31 May 2013

DARLEY AUSTRALIA – SUBMISSION ON MOUNT ARTHUR MODIFICATION ENVIRONMENTAL ASSESSMENT.

FIGURE 4 – VIEWPOINT LOCATIONS

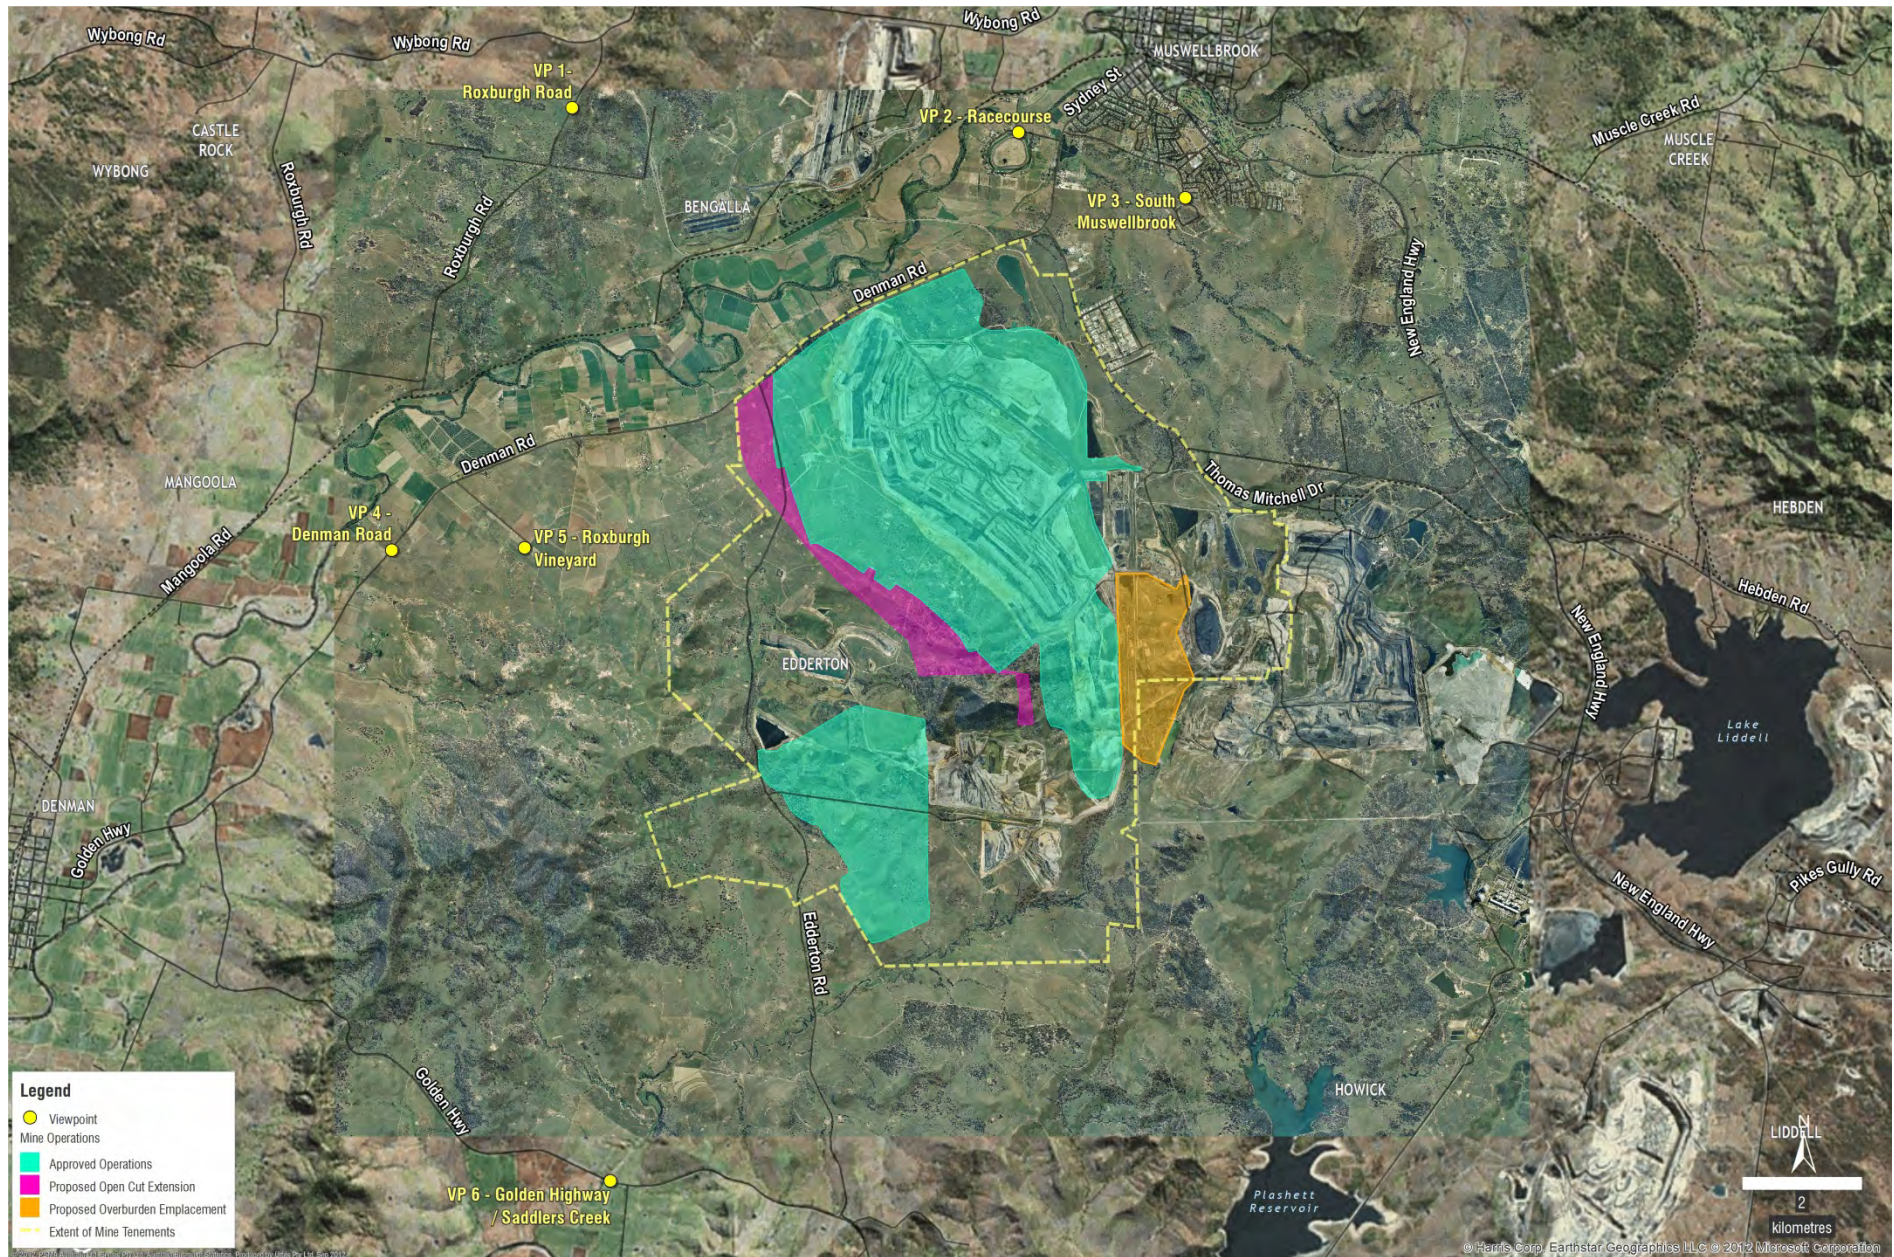
- the use of outdated 2009 viewpoints, which compound the EA's failings to identify viewpoints that visually impact on both public and private lands affected by this proposed Modification. It should be noted that the Woodlands property has been substantially enhanced and significant investment has been made in the property since Daley's acquisition and since the 2009 Visual Impact Assessment was undertaken;

- prepare photomontages from the elevated viewpoints on the Golden Highway and Trig Hill within the Darley Woodlands property to properly assess and demonstrate the potential visual impacts of the proposed Modification on private landholders and from the public domain;

FIGURE 5 – COMPARATIVE AREA OF ZVI OF APPROVED MINE AND PROPOSED MODIFICATION

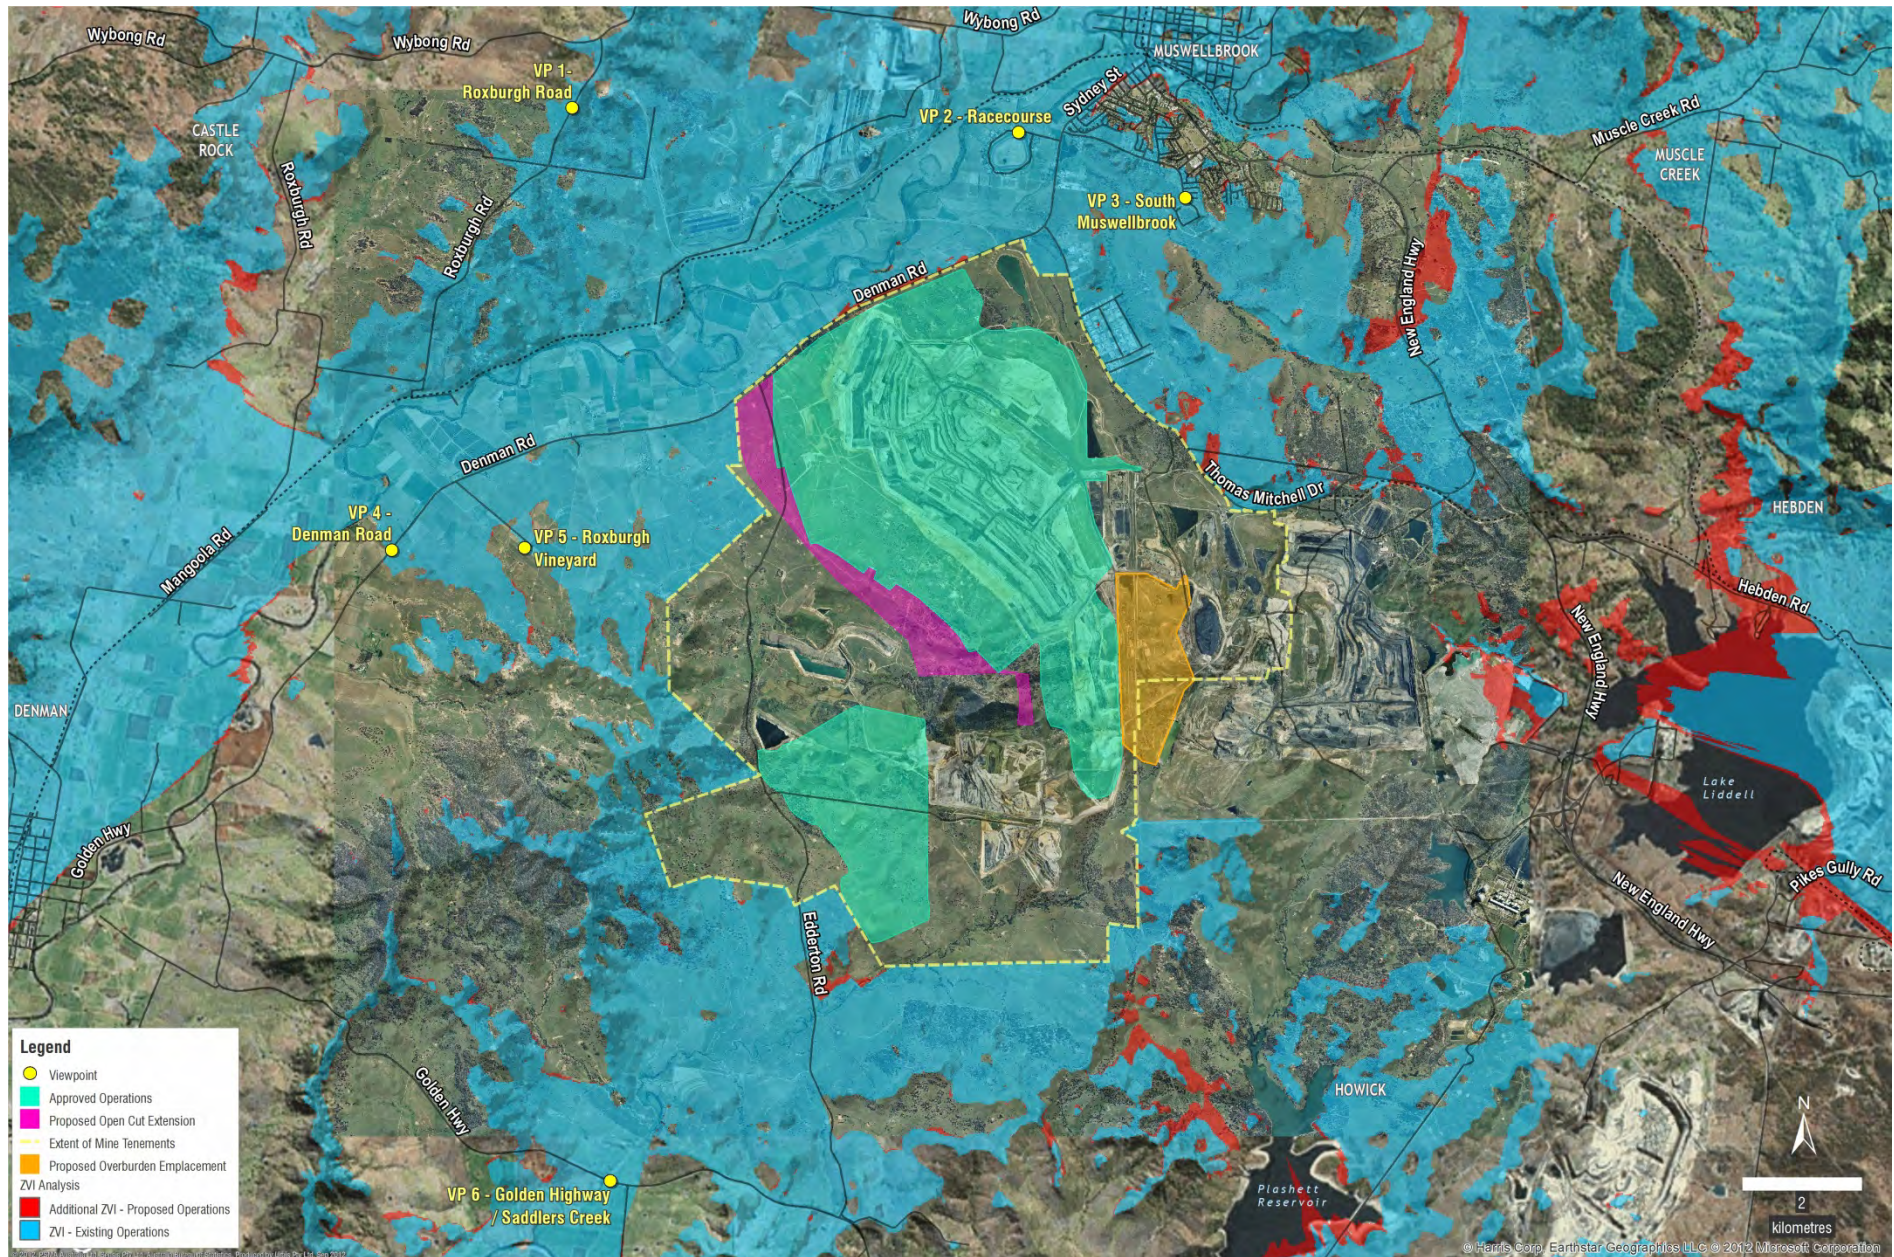
- advise whether Figures 4 and 5 correctly reflect the open cut mine footprint and if not correct these figures must be corrected and the visual impact assessment reviewed and updated to take any new footprint into account;
